Application No: WA/63/21/PL
Site Address: Land East of Tye Lane Walberton BN18 0LU
Description of works: Proposed alternative vehicular accesses off Tye Lane and emergency access off Avisford Park Road, along with minor highway works following WA/95/18/RES (resubmission following WA/93/20/PL). This site is CIL Zone 2 (Zero Rated) as other development.

Thank you for your internet representation made on 3rd August 2021 which has been recorded as an objection with the comments as follows:

Drawing Title:
PROPOSED ALTERNATIVE ACCESS

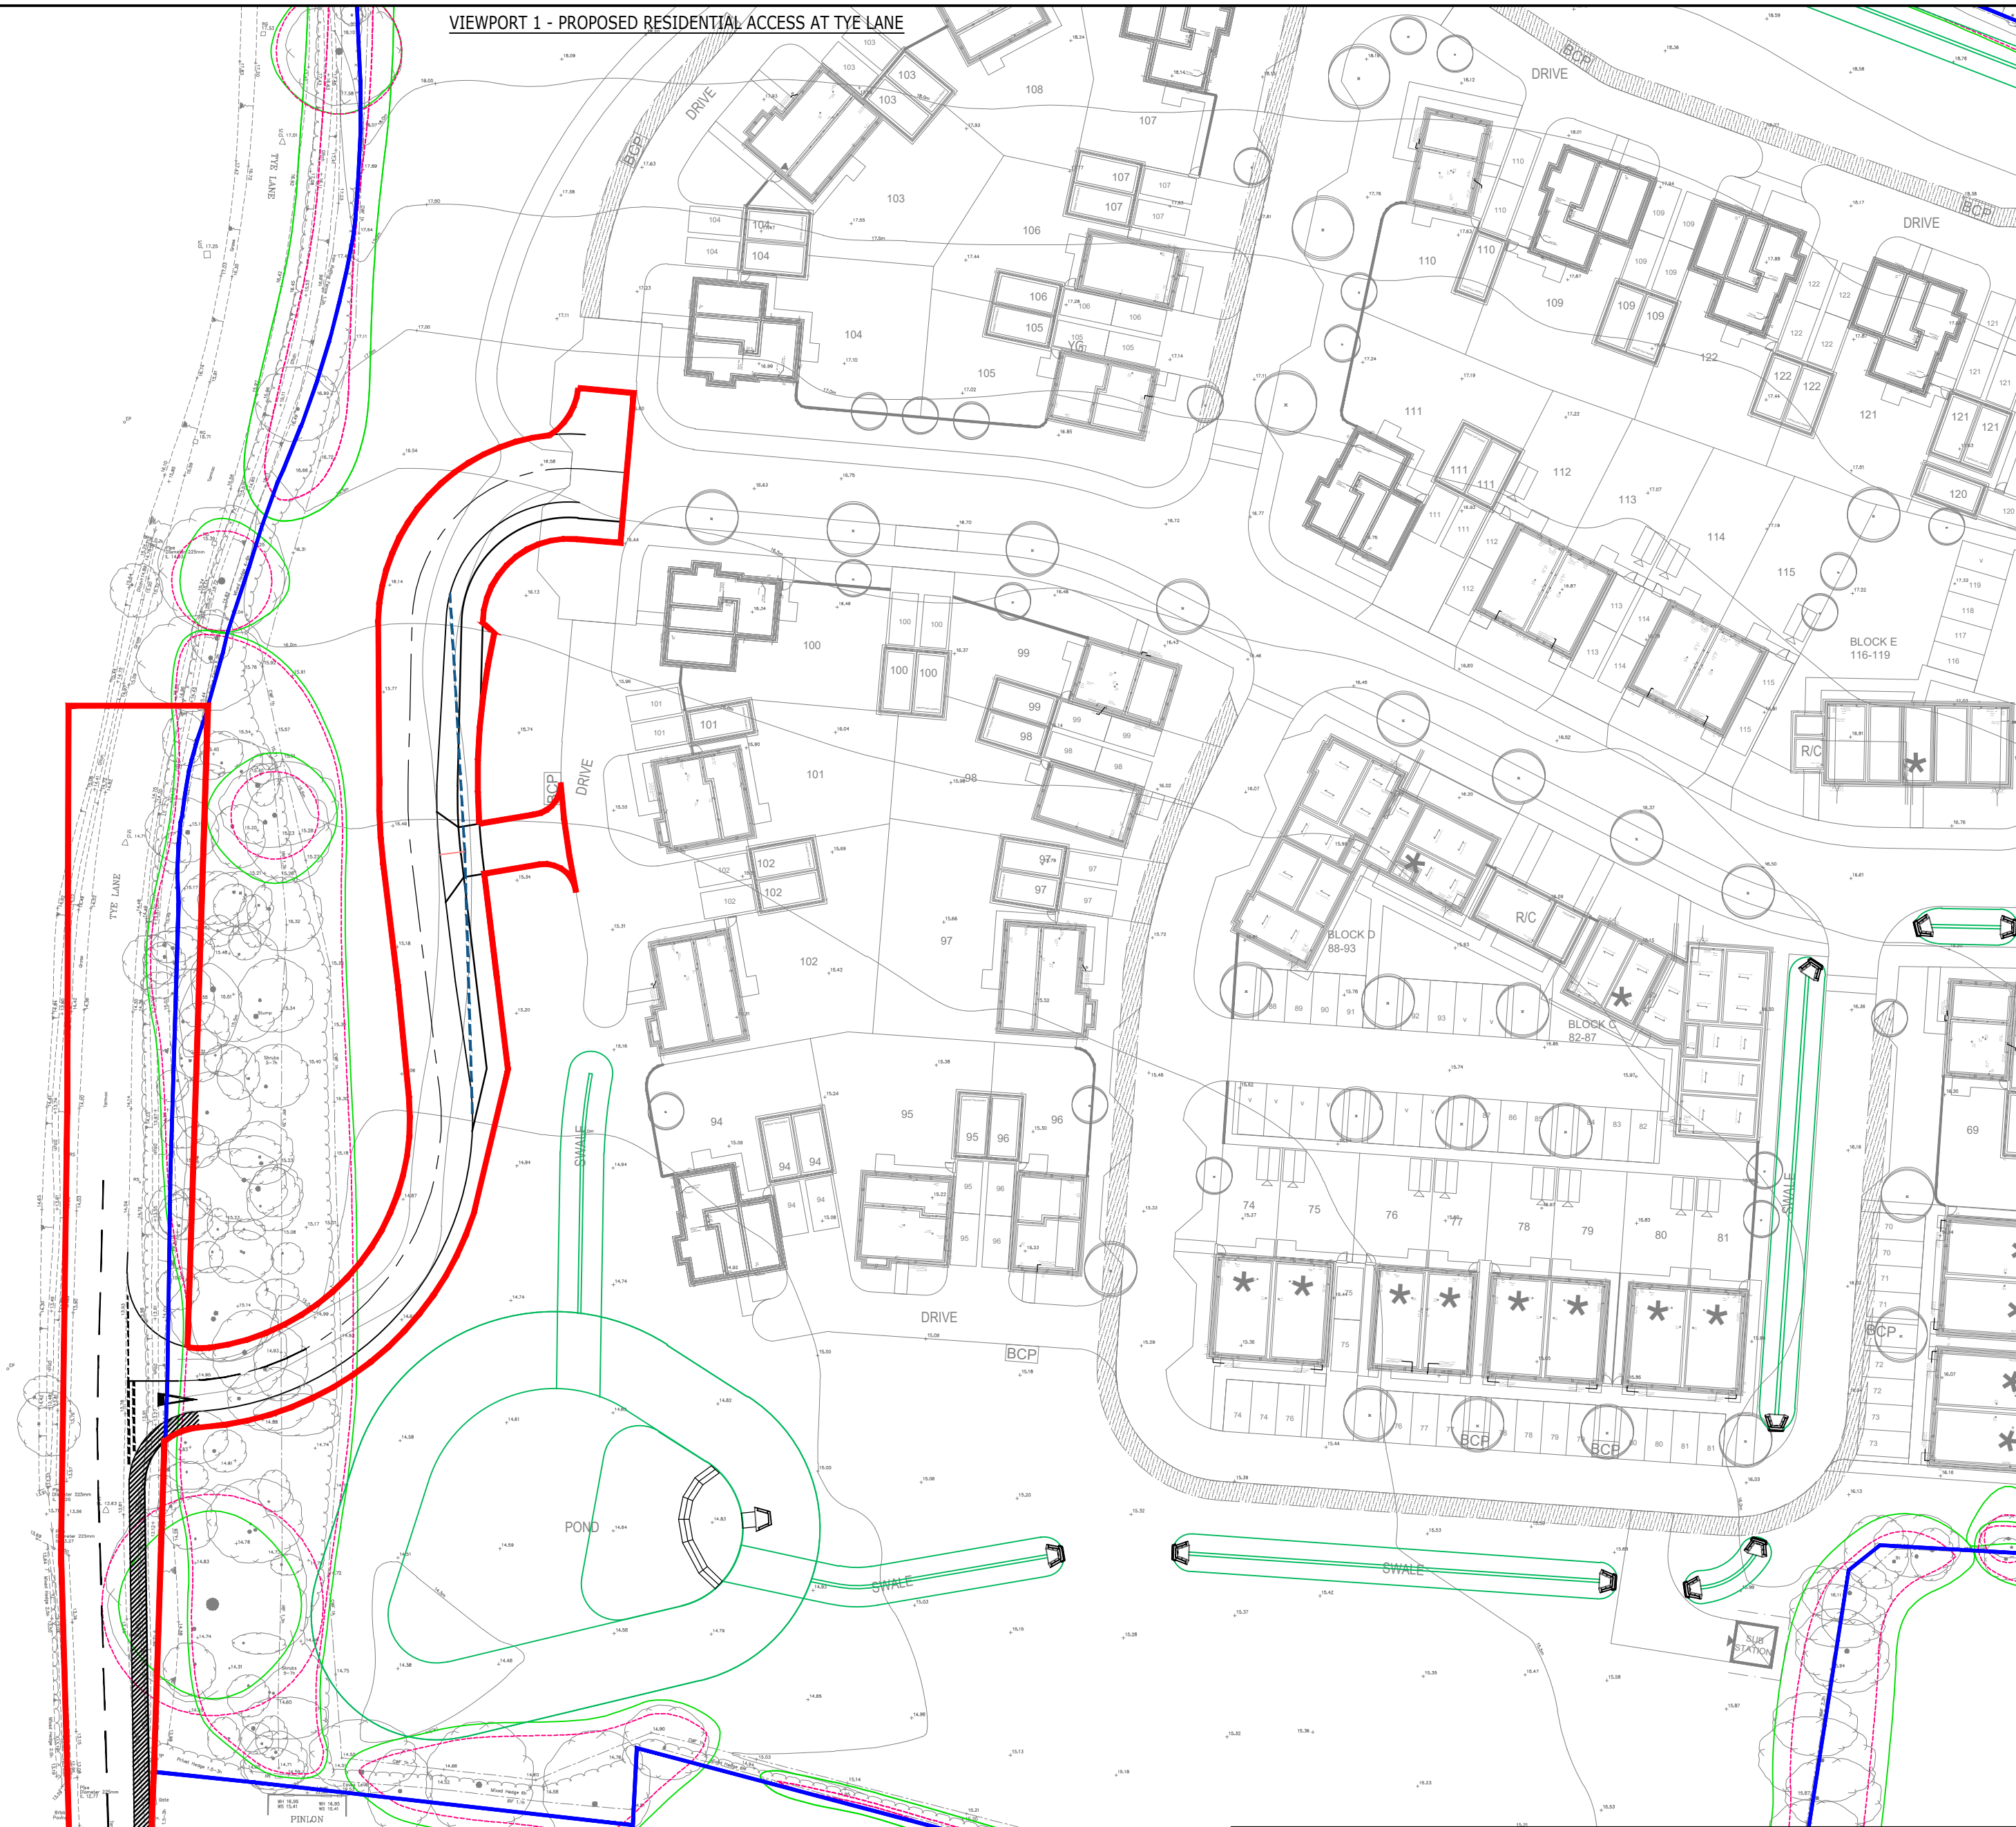
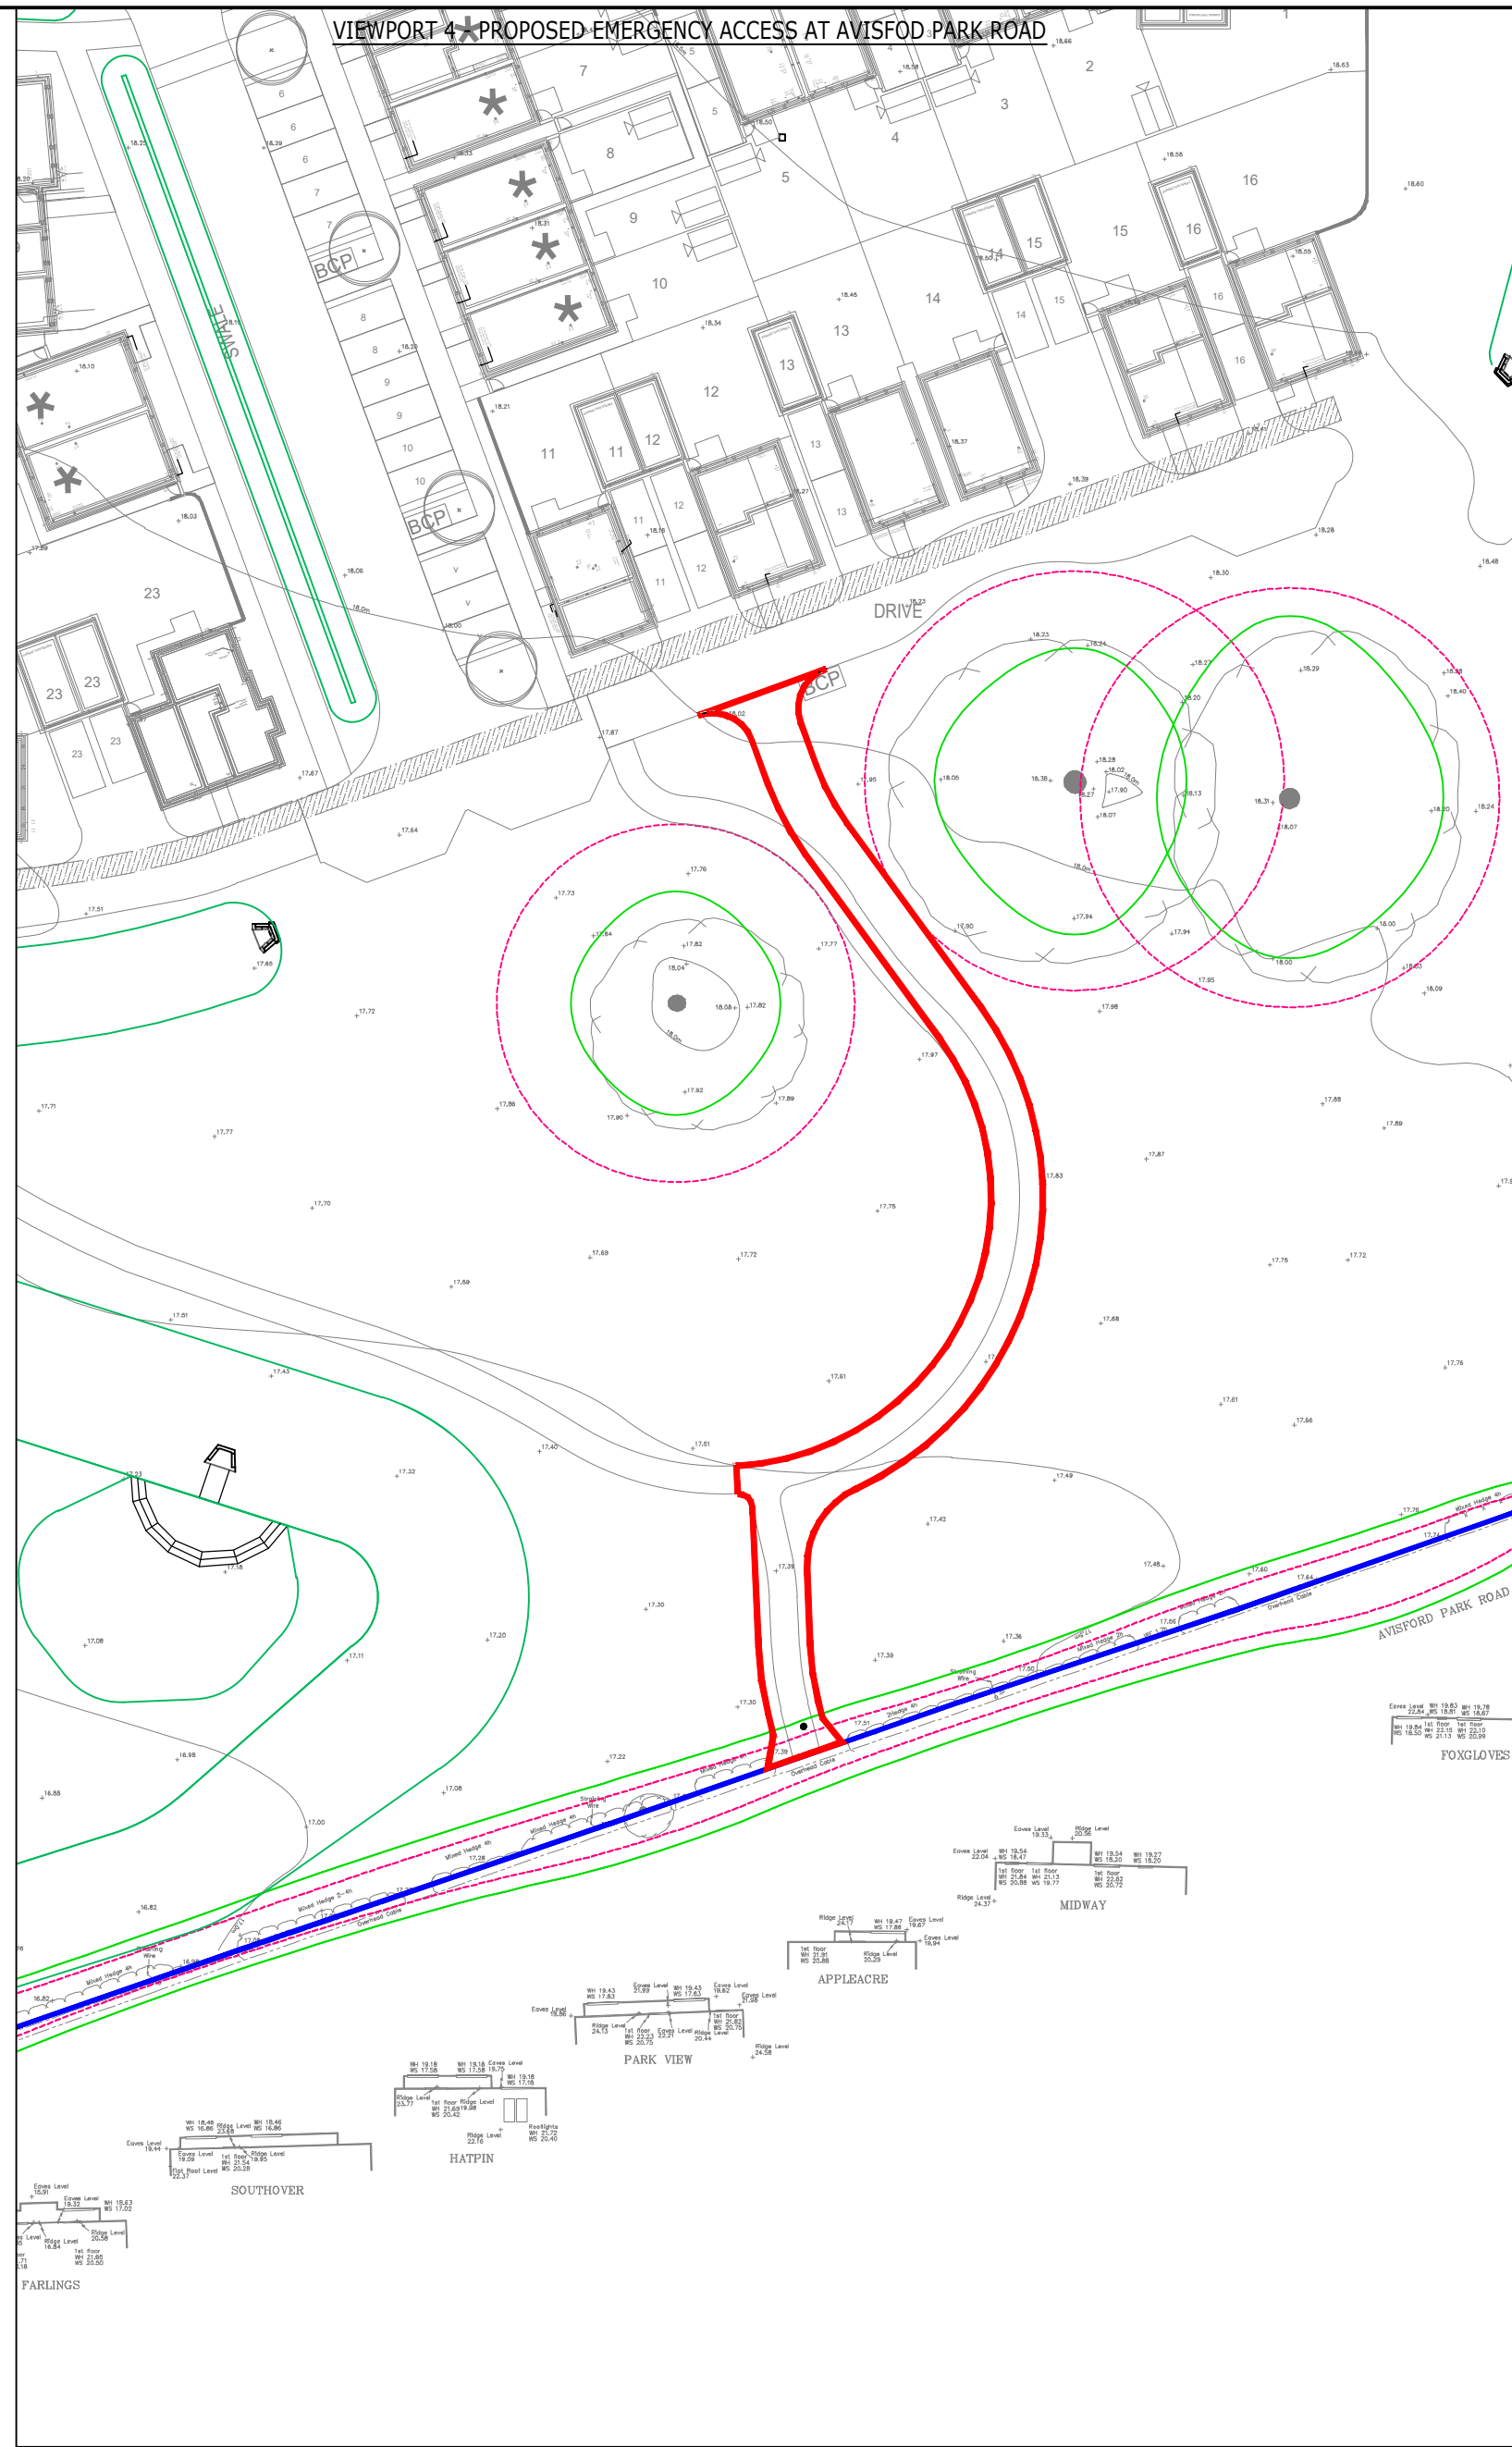
Tye Lane is significantly narrower than Yapton Lane for vehicle movements. The new application reduces Tye Lane to a minimum of 4.8m rather than 5.0m for approximately 25m which would mean that a HGV and a car could no longer pass at this point. 2 vans (2.4m wide) would be able to pass with zero clearance between vans and kerb and the vans themselves, encouraging vehicles to mount the pavement. 5 of the 6 houses at The Street end of Tye Lane have land ownership up to the current highway boundary. 2 of the houses do not have driveways or garages and cars are legally parked on the road further reducing safety if traffic along this road is to be increased. Parking on The Street can also impact on the visibility for vehicles pulling out into The Street at this junction.

The proposed cycle route from AG leads down this narrowed route which will pose increased risks to cyclist from traffic trying to pass them. The reduced road width to accommodate the new access point poses increased dangers to pedestrians, cyclists, horse riders and vehicular traffic.
